Re: Venetucci Thompson Thrift
Traffic Impact Study
El Paso County, Colorado

Thank you for the Traffic Impact Study email dated June 27, 2023 for the Venetucci Thompson Thrift project. We held a meeting Gilbert LaForce at El Paso County (traffic engineering reviewer), and have made several updates as a result of this meeting and summarized below based on this meeting and your prior comments:

Venetucci Thompson Thrift El Paso County, Colorado

FIGURE 11
 VENETUCCI THOMPSON THRIFT
 EL PASO COUNTY, COLORADO
 ROADWAY OWNERSHIP MAP

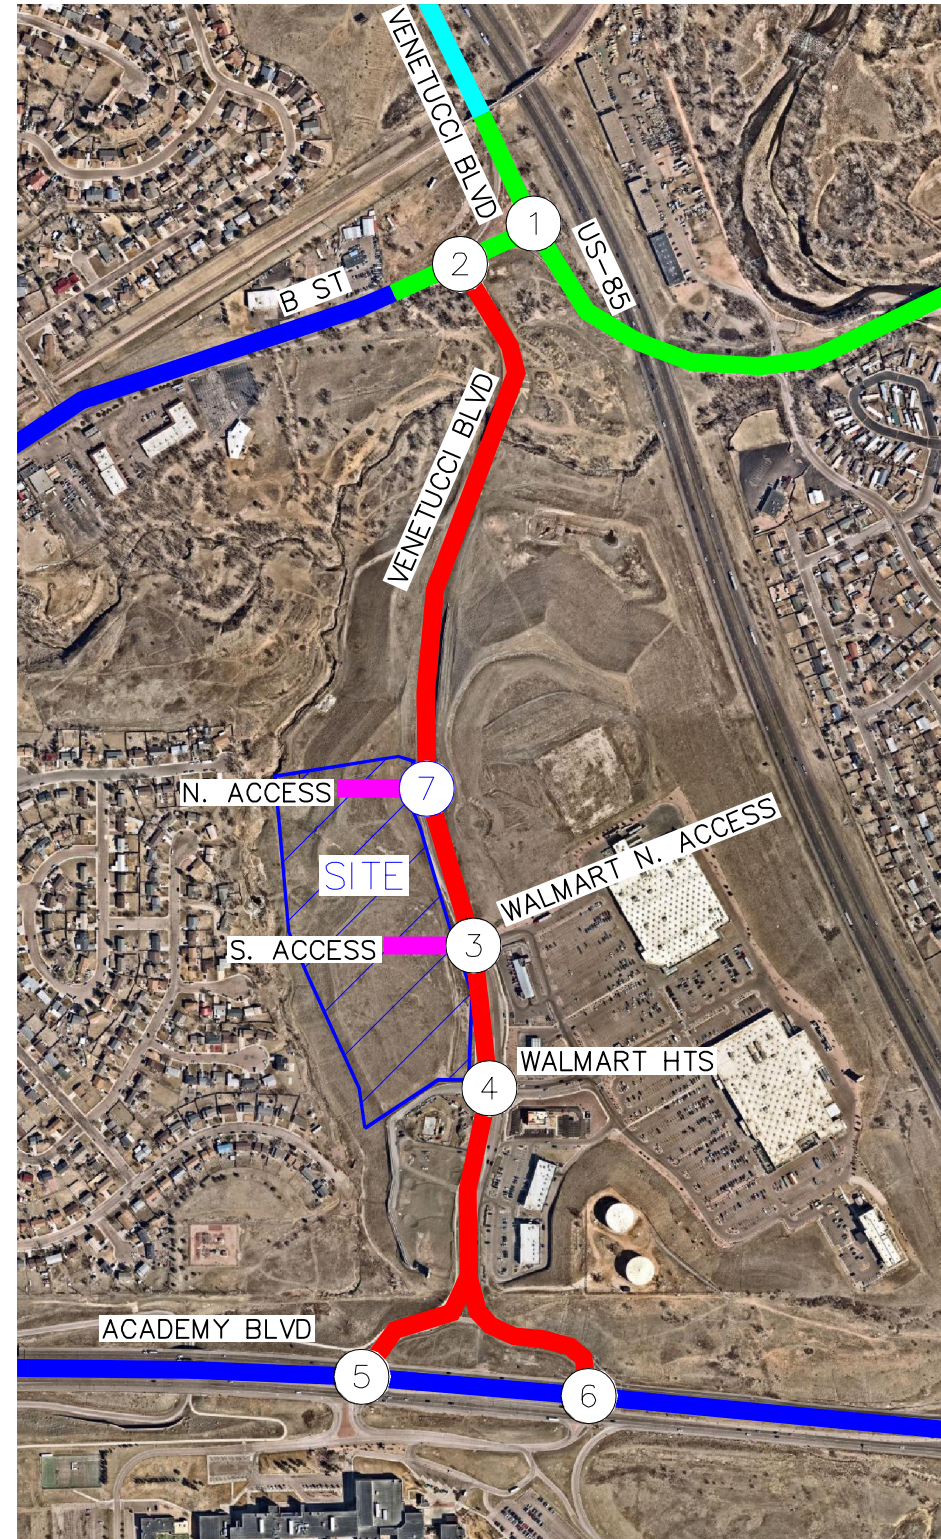
- Based on the request of Gilbert LaForce at El Paso County, we have been in correspondence with CDOT, City of Fountain, City of Colorado Springs, and El Paso County to determine which agency controls each of the roadways in the surrounding area. This is now identified in Figure 11.

FIGURE 12
VENETUCCI THOMPSON THRIFT
EL PASO COUNTY, COLORADO
2025 RECOMMENDED GEOMETRY AND CONTROL

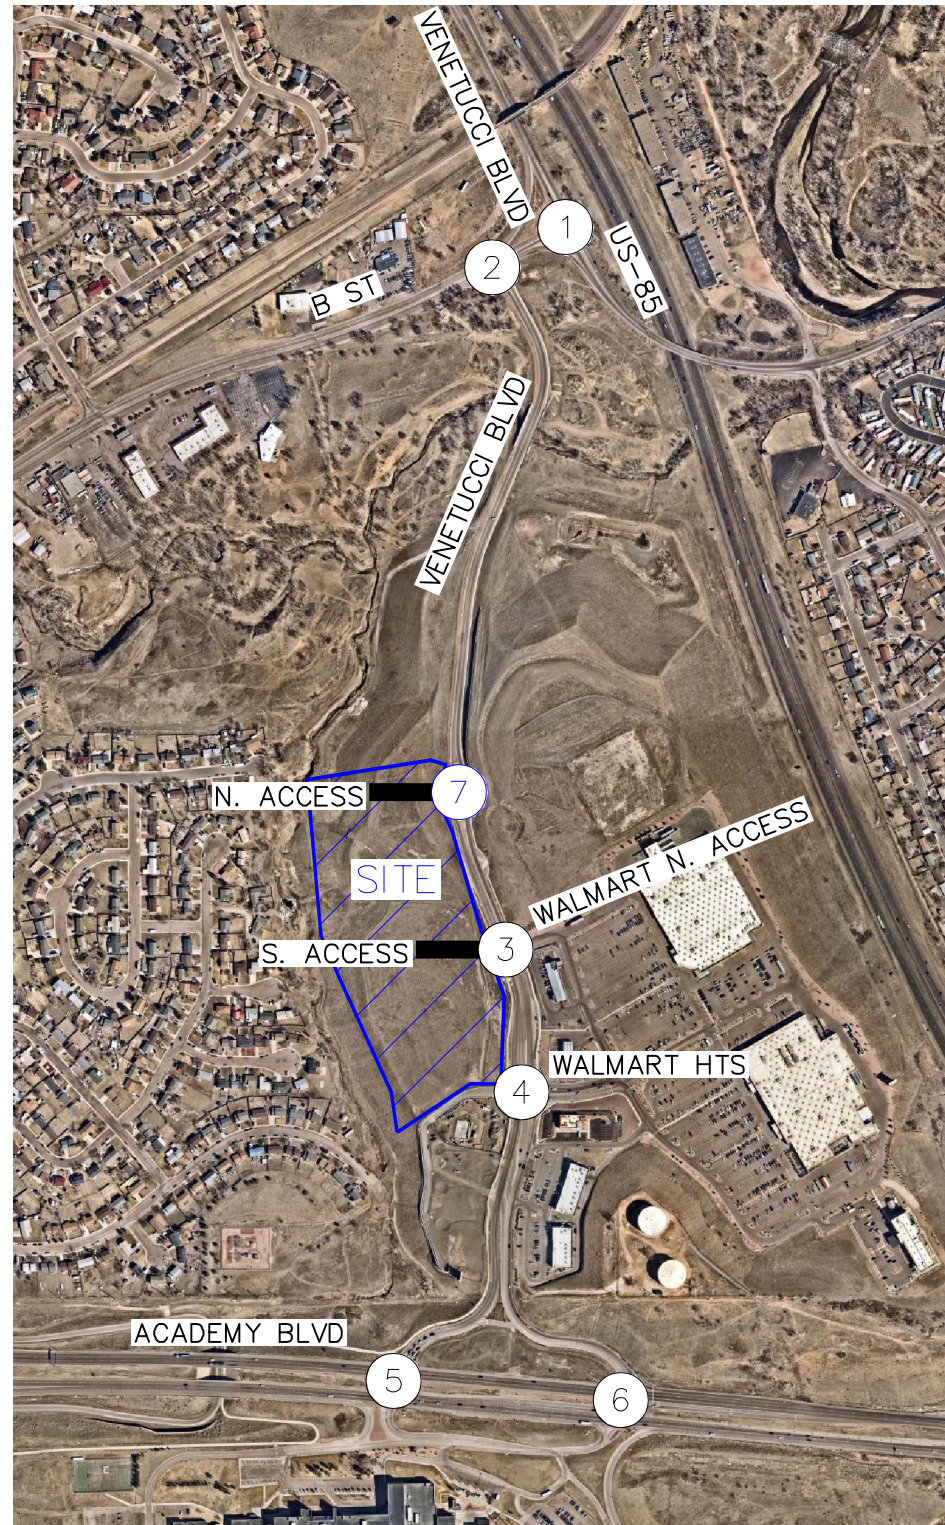
- CDOT was previously exploring the possibility of combining the two T-intersections of B Street/Venetucci Blvd and B Street/US-85 as one four legged roundabout intersection. This has since been put on pause and we have identified a much cheaper alternative (eastbound dual left turn lanes); therefore, we have removed the additional analysis with roundabout control to avoid any chance of being held responsible for those improvements. We have acknowledged our understanding of the possible roundabout and added the following statement, "It is understood that the intersection of B Street and US-85 may be combined with the intersection of B Street and Venetucci Boulevard (#2) in the future as a four-leg roundabout. If pursued in the future, this roundabout configuration will be evaluated by others and was not evaluated in this study due to the current configuration of this intersection operating acceptably and vehicle queues being mitigated with the implementation of eastbound dual left turn lanes."

- Further, an eastbound right turn lane is warranted at the B Street and Venetucci Boulevard intersection based on El Paso County standards and existing traffic volumes. To meet El Paso County standards, this right turn lane should provide a length of 305 feet with a 160-foot taper. Of note, this eastbound right turn lane is warranted based on existing traffic volumes while project traffic is expected to contribute to approximately 4.1 percent of the eastbound right turn movements at this intersection in 2025 (also reported in Table 12 and discussed is several locations).
